RE: Responses to Pre-Application Comments  
White Barn Brown Bear Carwash  
8833 Soper Hill Road, Marysville, Washington  
City File No. 23005  
Our Job No. 22681

## **Pre-Application Conference – Response to Comments**

Job Number
22681
 Sheet
CWA2.2
 of

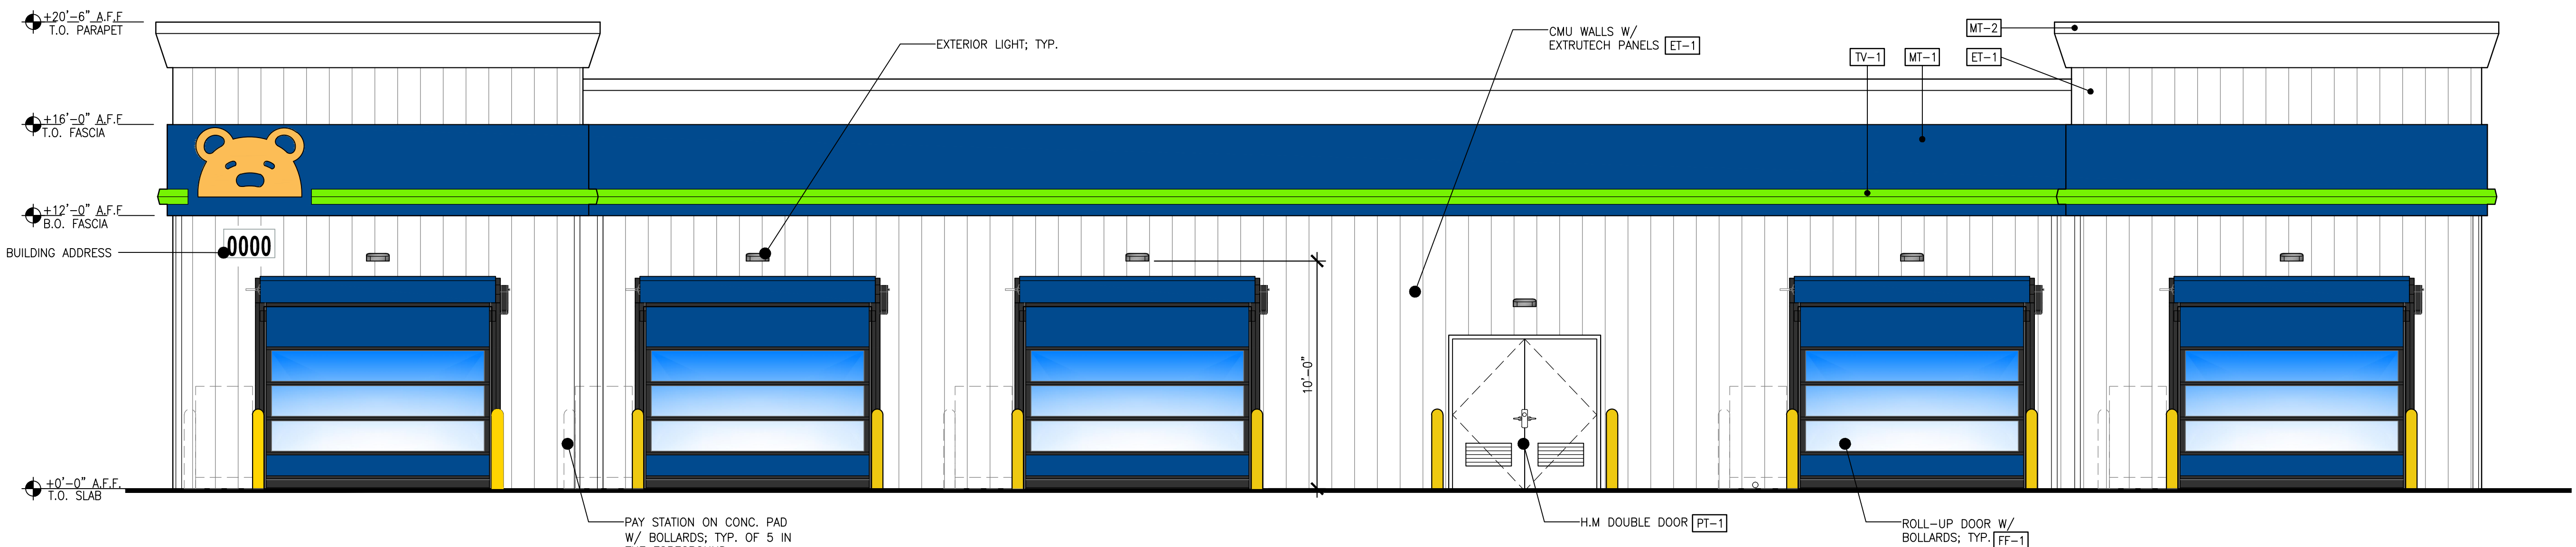
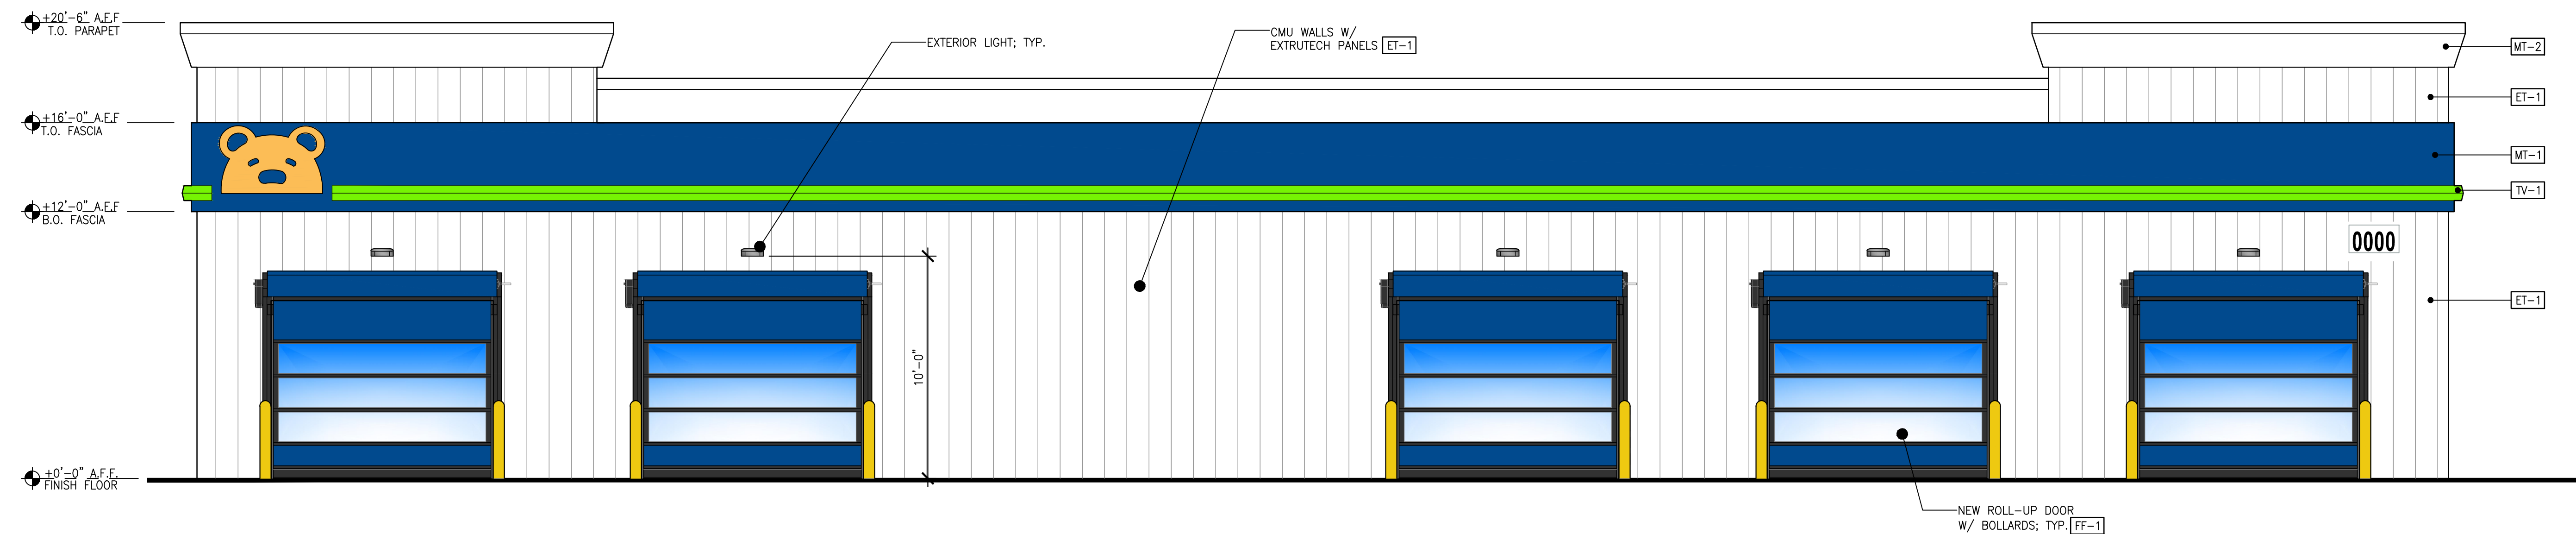
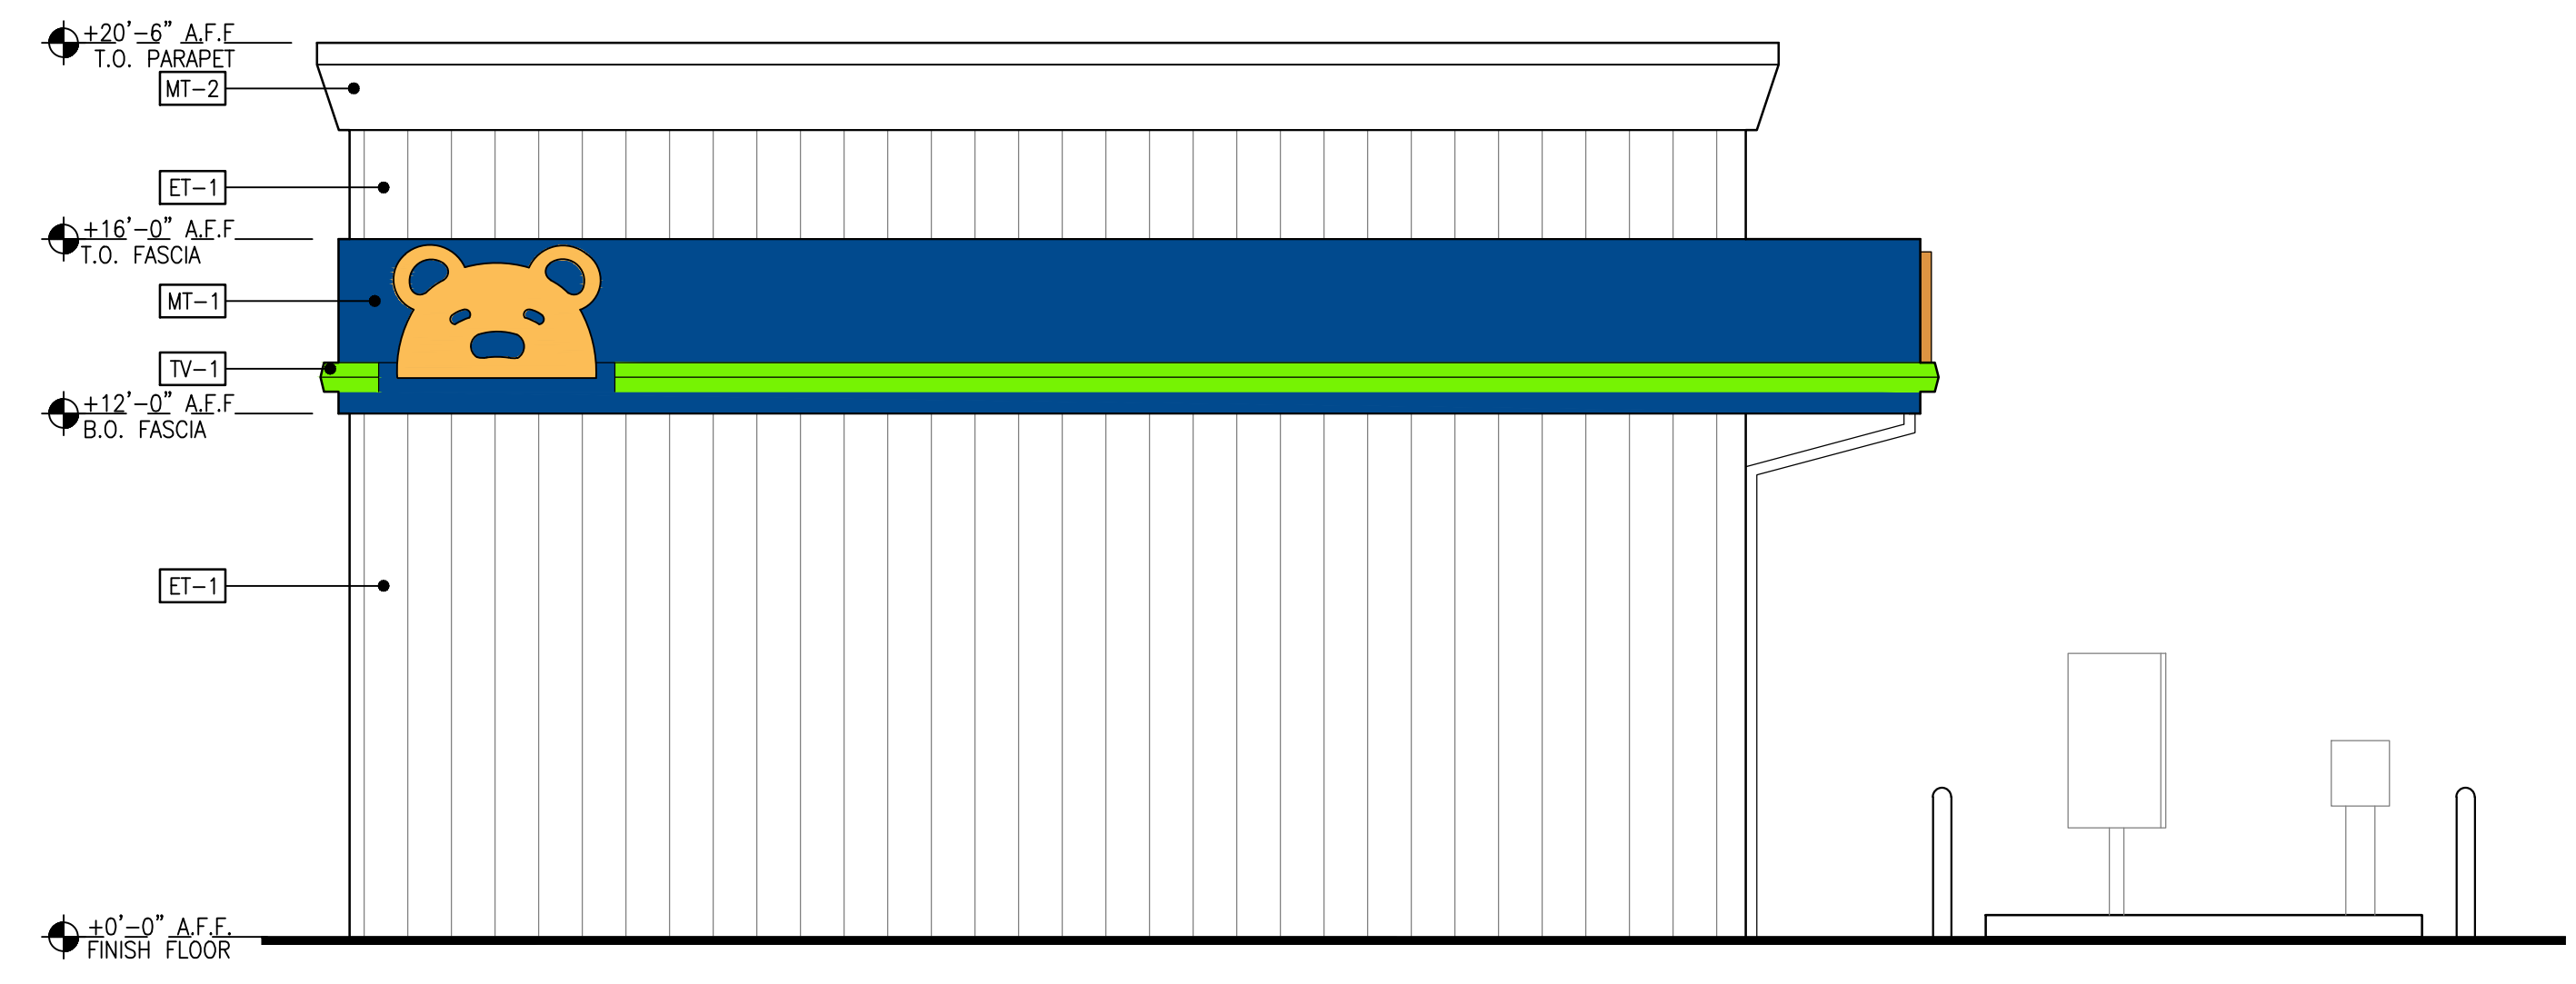
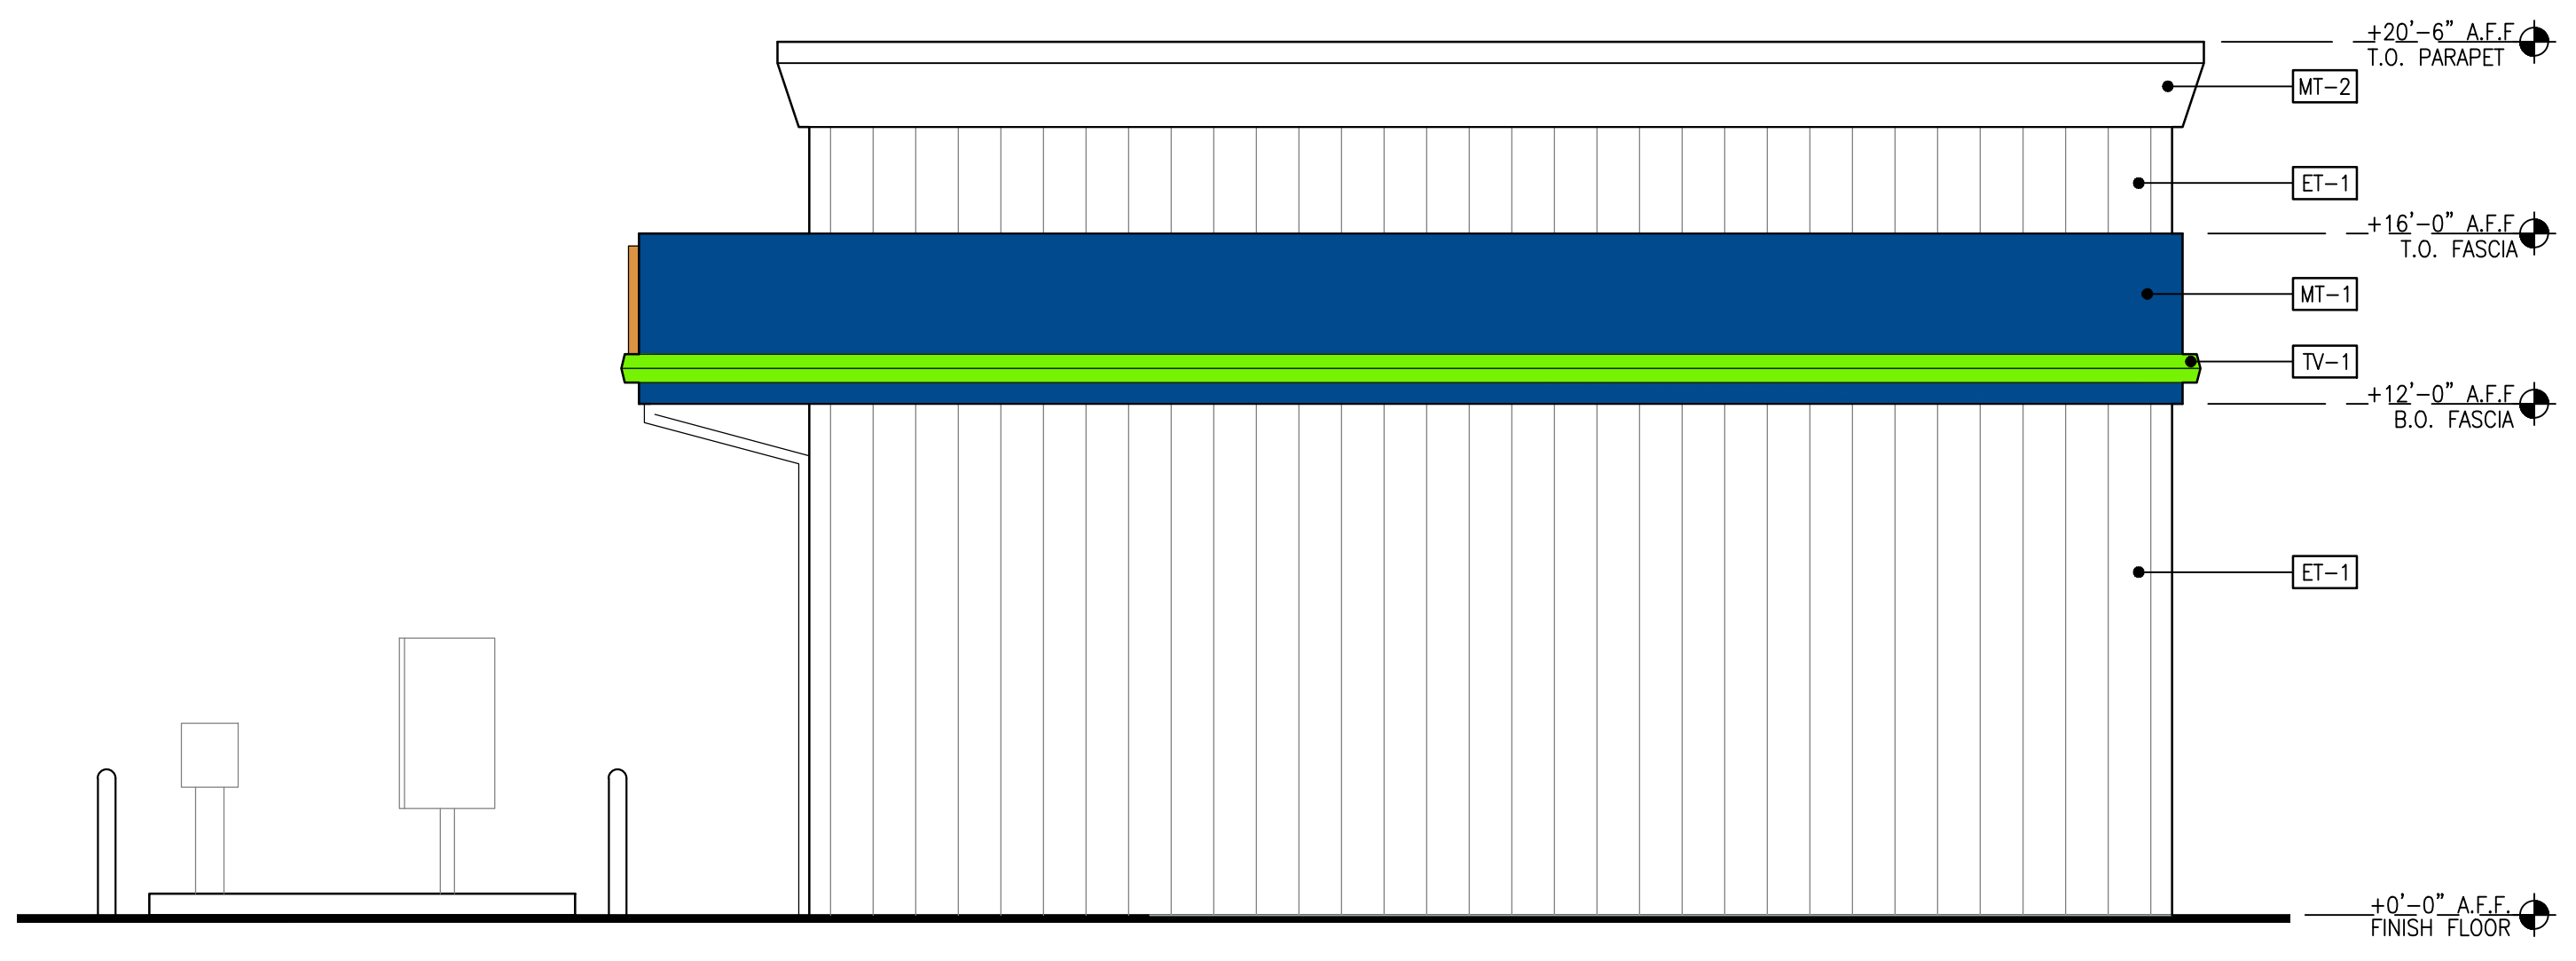
- a. *MMC 22C.070.080(2)(c): Buildings shall be located and oriented towards the street. To meet this requirement, the building entries and windows must face the street. Specific provisions and exceptions include:*

- Parking lots shall not be located between the building and the street.*
- Building facades facing the street must have transparent windows or doors covering at least 25% of the ground floor facade between 4-8 feet above the level of the sidewalk. Departures will be considered by the Director provided the proposed building configuration and design enhances the pedestrian environment of the neighborhood.*

**Response:** Please see Sheet C1.0. The auto sentry building is oriented towards the street. The auto sentry building will screen drive-thru areas from the street and meets the transparency requirements. Please see sheet CWA2.2 for the elevation view of the auto sentry building.
